## **Response to Planning Application**

**Application ref:** Y/53/21/DOC

**Description:** Approval of details reserved by condition imposed under ref APP/C3810/V/16/3158261 (Y/19/16/OUT) relating to Condition No 11 - timetable for provision & future maintenance of Public Open Spaces.

**Location:** Burndell Road, Yapton

DATE: 13/04/21
QUOTE NO: Q6301_D
DRAWING NO: Q6301_A
PROJECT: Q6301_Yapton LAP 1
CUSTOMER: Natalie Bond
ADDRESS: Bovis Homes Southern Counties
 Central 40
 Lime Tree Way
 Chineham Park
 Basingstoke RG24 8GU
TELEPHONE: 01256 674100
EMAIL: Natalie.Bond@bovishomes.co.uk

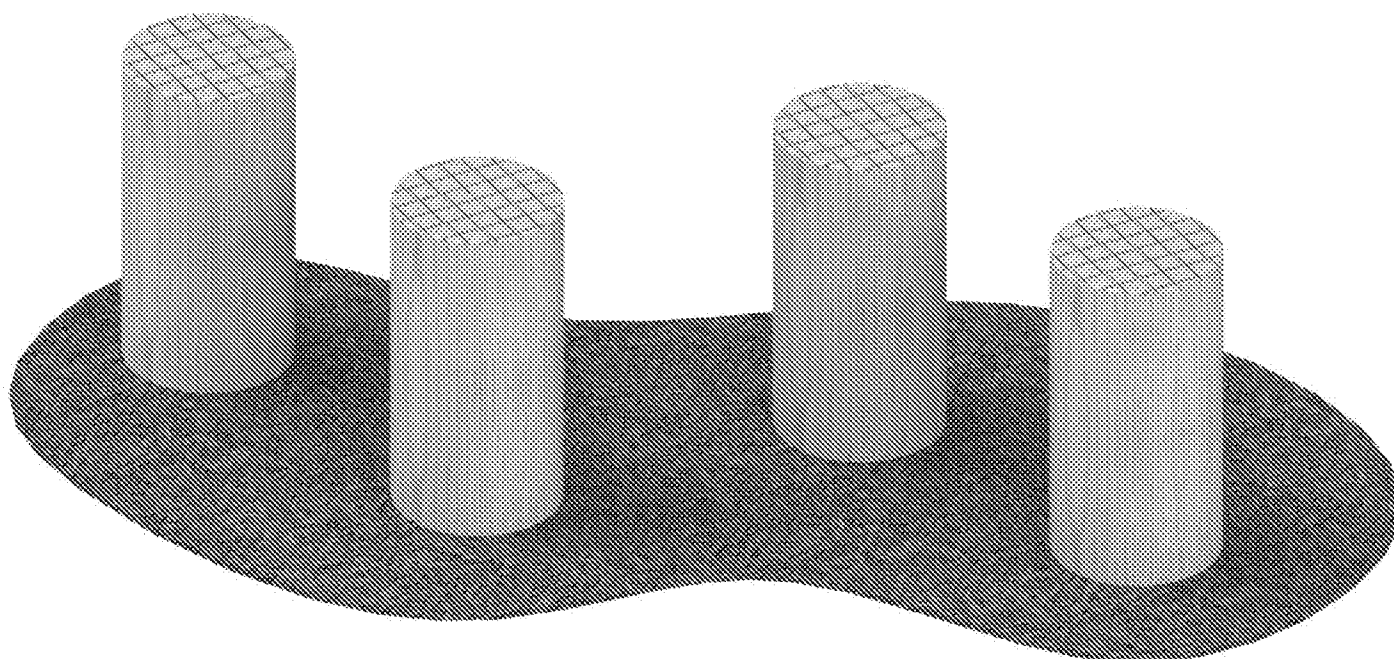
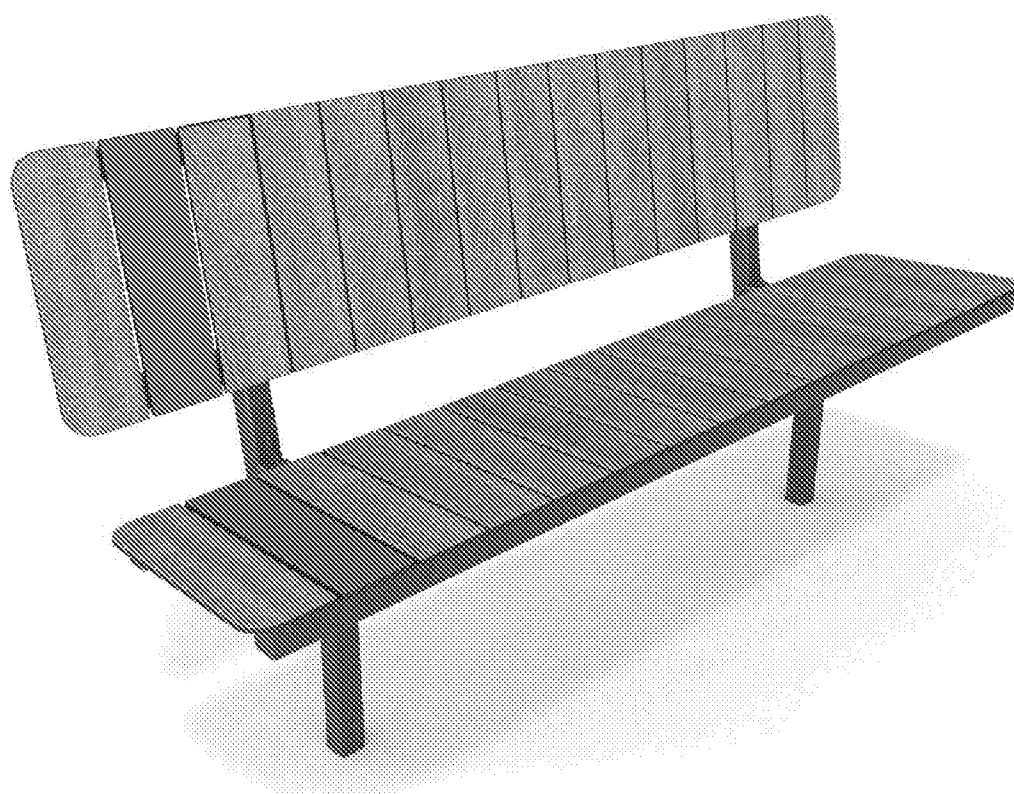
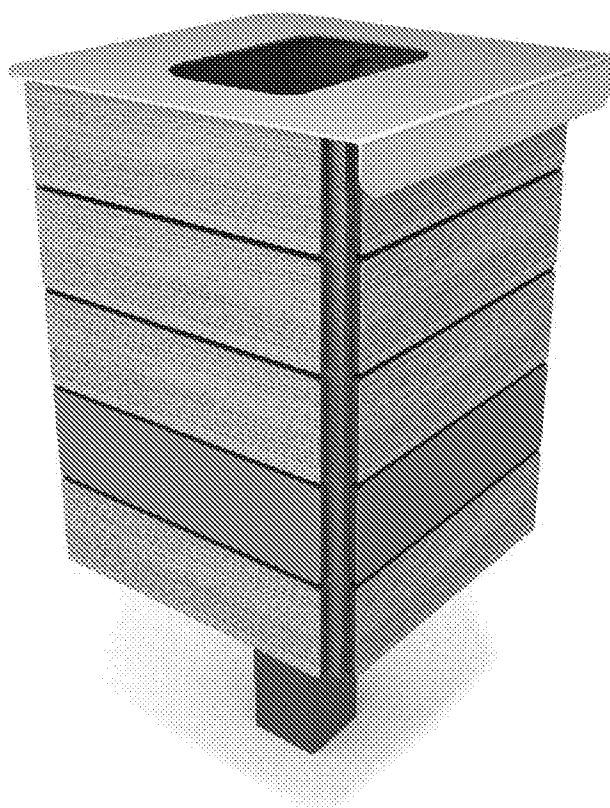
- LAP 1 & LAP 2 contain natural play features and meet our LAP criteria.
- LEAP – Includes the additional springer and the swing seat variations and now allows for improved flow through the play area. This now meets our criteria re play experiences, layout and importantly has included an element of inclusive play.
